PLANNING PRE-APPLICATION SUMMARY REPORT

Application number 24/00085/MOR

Applicant's address 4-6 Royal Parade

Pre-application for vinyl graphics installed internally, LED backlit illuminated signage 50mm thick above door space and Fascia board trays

Shopfront Elevation 1:100

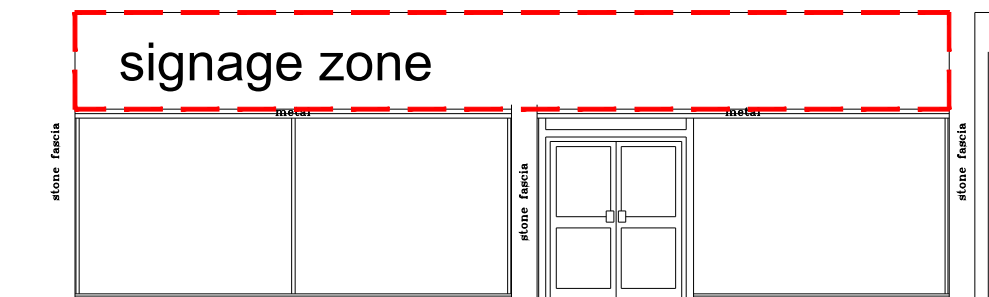
Officers raise no significant concerns with the proposed fascia signs, as they are considered to be appropriately located within the context of the shopfront, and are in proportion to the shopfront within which they sit.

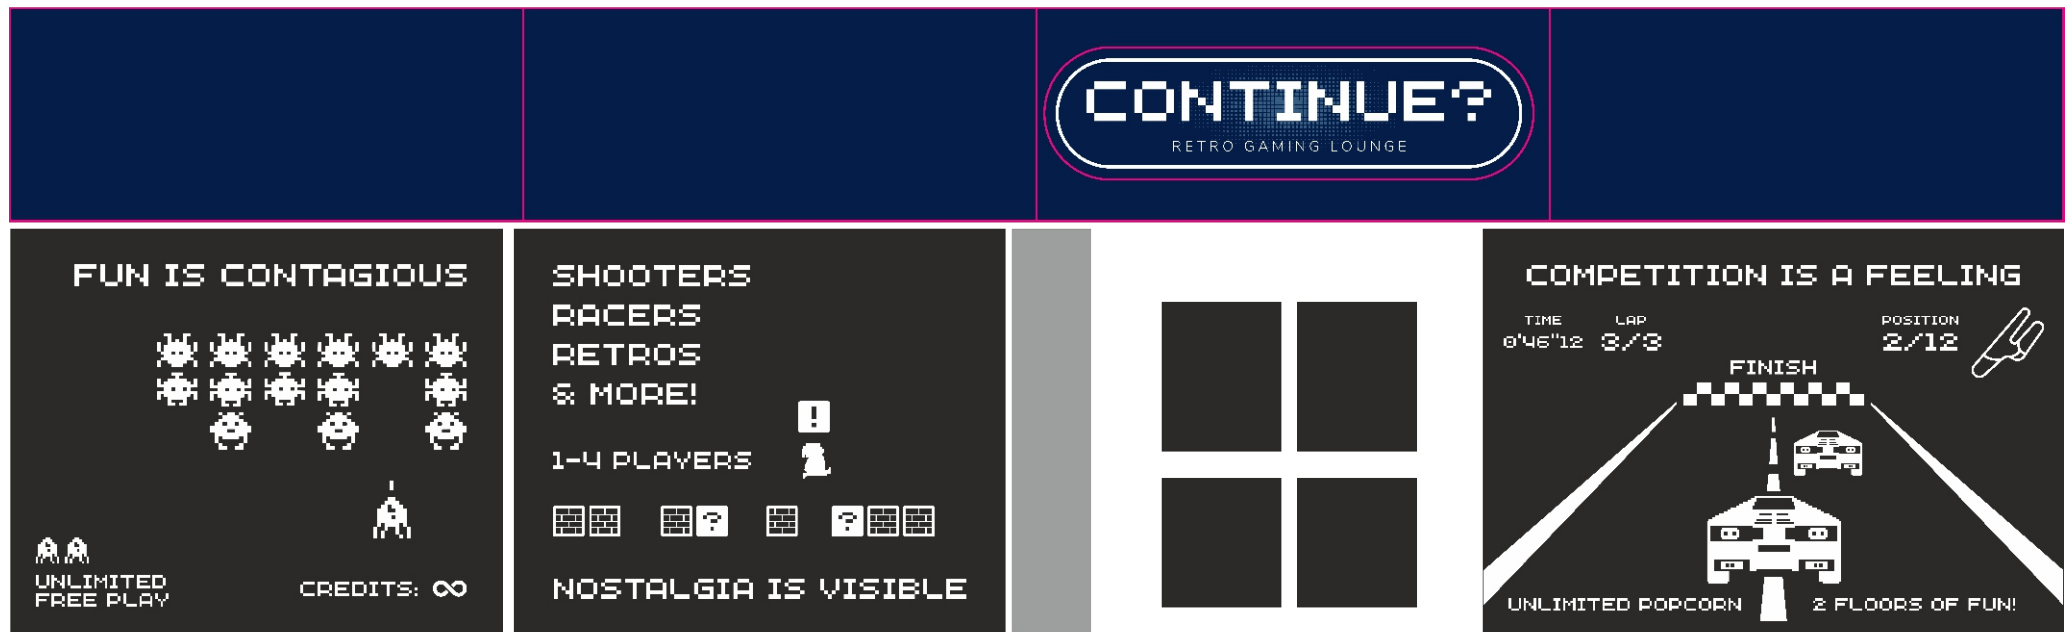
Guidance in the SPD states that developments should have active frontages, particularly at ground floor level. Officers have assessed the proposed vinyl and consider that they would not provide an active frontage due to the opaque design making up most of the proposed vinyl. In order to be found acceptable by the Local Planning Authority, no more than 30% of the shopfront should be obscured by opaque vinyl. This is particularly important considering the prominence of the site, within a busy part of the city centre. It is acknowledged that the proposed vinyl is likely to create a darker environment inside the unit, to support the arcade use. However, the Urban Design Team recommend that consideration of the internal arrangement to create an adequately dark space would be more acceptable from a visual impact perspective.

Officers therefore find the vinyl currently proposed to be incongruous with the surrounding area, and unable to provide adequate active frontage, as such it is considered contrary to policies protecting visual amenity.

Officers consider that there are limited examples of illuminated signage in the neighbouring units. No details have been provided on the level of illumination proposed, and as such officers recommend that these levels are in-keeping with units within the locality, and would not be so bright as to lead to harmful amenity impacts.

It is noted that the signage is proposed to make use of "high-quality materials", with details confirming the use of aluminium and acrylic, however no further details have been received at this stage. Consultation with urban design agree that signage should be constructed of high-quality materials, and support the use of aluminium. They also raise that signage with 3D cut lettering would be preferable to flat printed signage, particularly due to the prominent location.

“Large areas of glazing is an important feature of shopfronts of this period, so goods and displays can attract attention from outside. Therefore:
[...] windows will be unincumbered by excessive advertising and signage, such as posters, and will not be boarded up”.

It is further noted within the CAAMP that signage should not be internally illuminated.

Officers advise that a significant reduction in the vinyl, and the inclusion of non-illuminated signage would be likely to be supported by the Local Planning Authority.
